From: Fiona Fitzgerald
Sent: 05 August 2014 09:07
To: Cian Cronin
Subject: FW: Planning Consultation on: BR/170/14/PL

APPLICATION NO: BR/170/14/PL

Site Address: Butlins Upper Bognor Road Bognor Regis PO21 1JJ

Description of Works: Erection of a temporary marquee for use as an additional summer entertainment venue between the months of June to September for a period of 5 years

Site Layout Plan

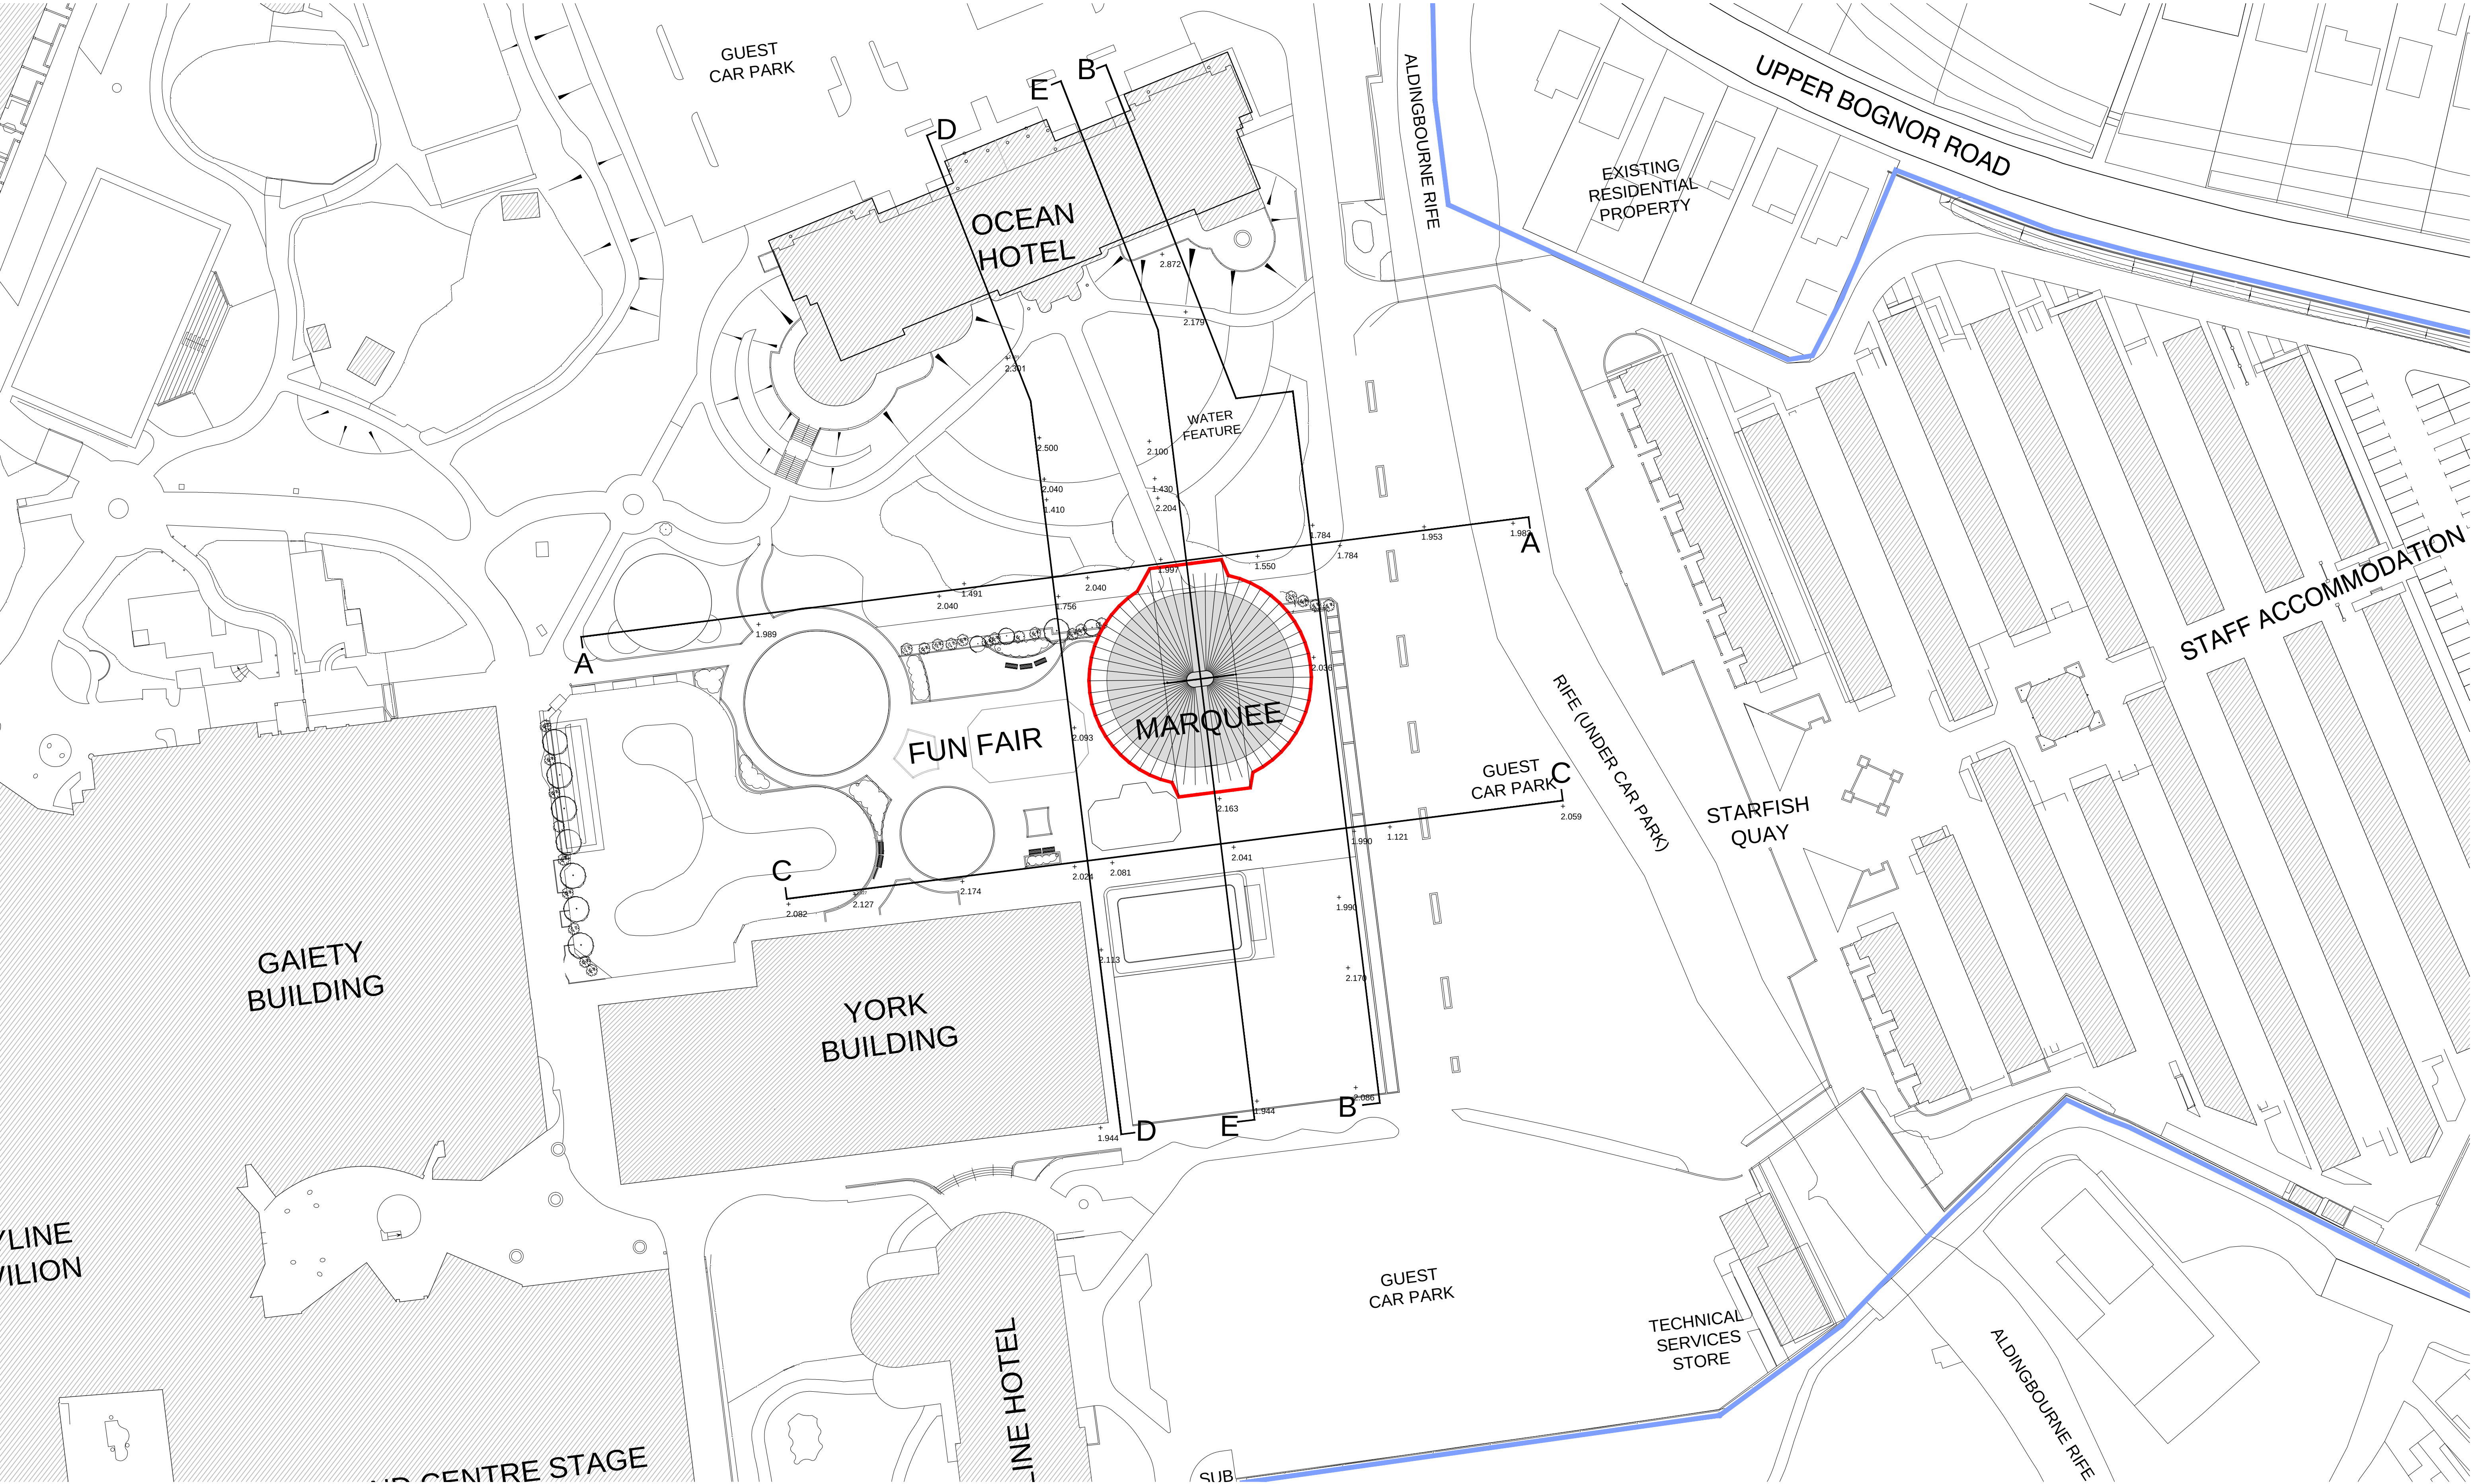
A marquee provides negligible attenuation to the passage of sound. There is insufficient information in the application to satisfy that amplified sound (music/announcements etc.) will not be audible beyond the site boundary. Additional audience/customer noise associated with entertainments may also increase noise levels above the existing background at nearby noise sensitive premises. Please ask the applicant to provide an acoustic consultant's report quantifying the impact upon residential premises and detailing mitigation measures should be required to support the application.
